## TOWN AND COUNTRY PLANNING ACT 1990 FULL

**Reference:** H18-0383-25 **Date of Decision:** 16th June 2025  
**Applicant:** S E King Building Contractors Ltd  
Orchard House  
107 New Road  
Sutton Bridge  
Spalding  
PE12 9QA  
**Location:** Rear Of 210 New Road Sutton Bridge Spalding Lincolnshire  
**Description:** Demolition of existing barn & erection of 1 dwelling & garage

Drawing
 ELEVATIONS & GARAGE

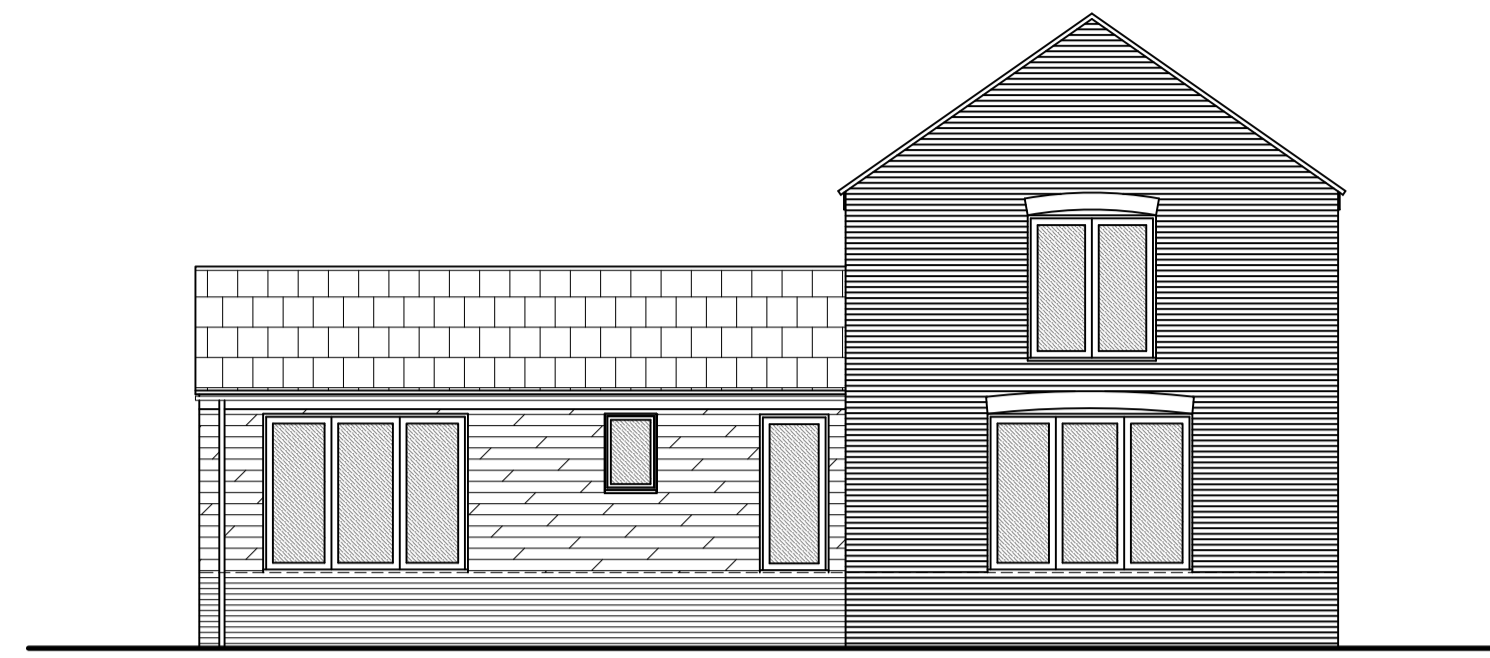
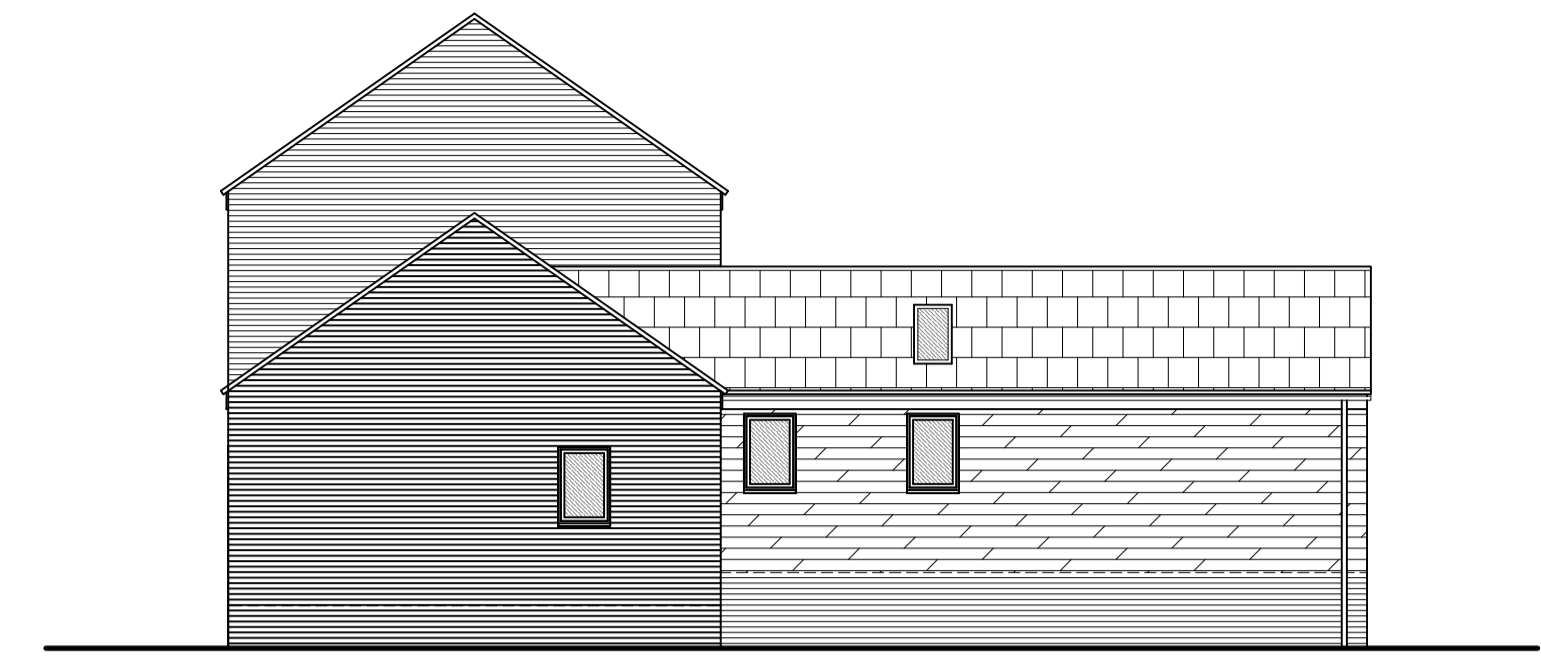
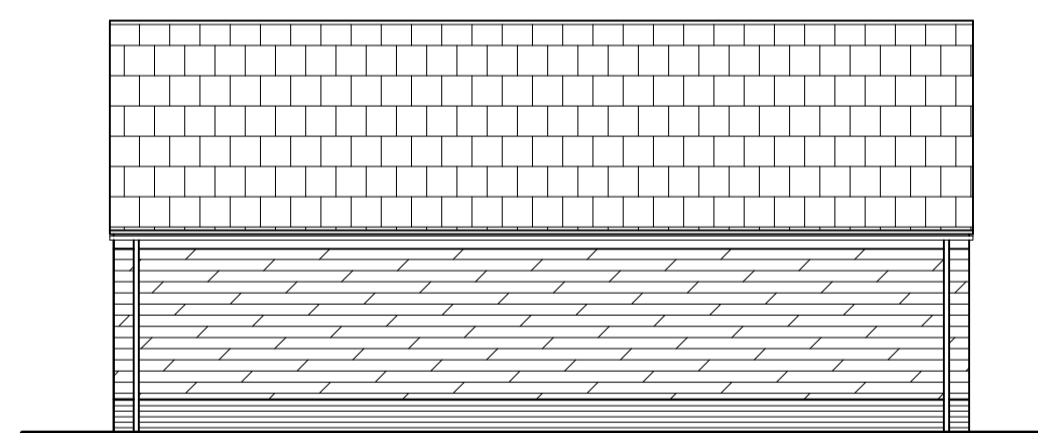
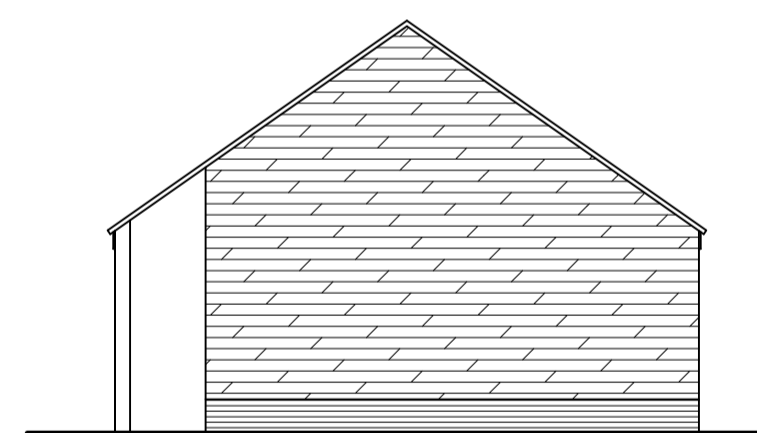
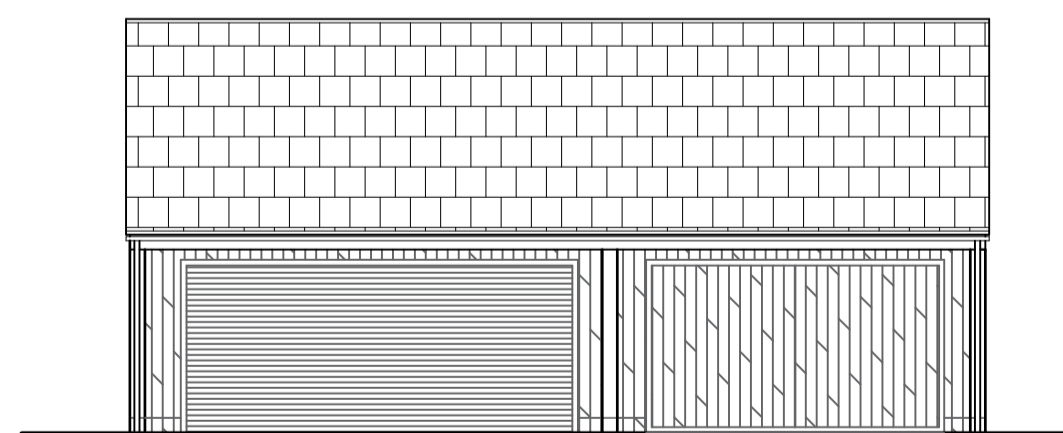
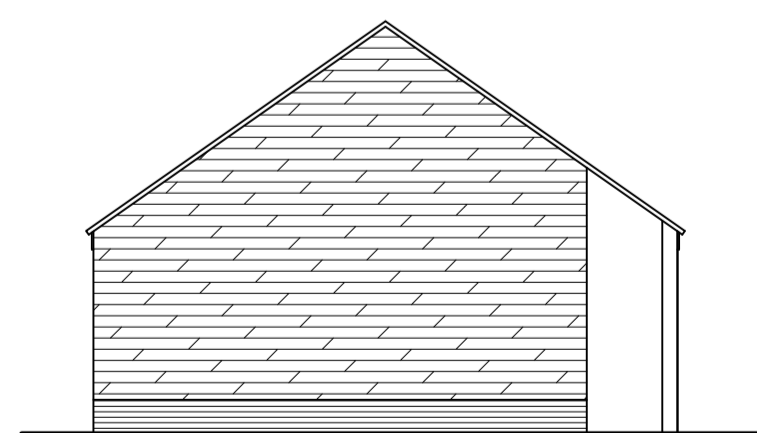
The proposal by virtue of its appearance through the materials and design lack a high quality architectural merit meaning it is not considered to be a betterment to the site and surrounding area. It would result in a loss of a well established agricultural barn and does

not appear similar to other existing dwellings located along New Road, Sutton Bridge. Furthermore, it is not representative of the agricultural barn in any capacity and greatly contradicts the existing development. Overall, it fails to recognise the intrinsic beauty of the area with the standard urban design making it appear incongruous whilst not enhancing or improving the area.
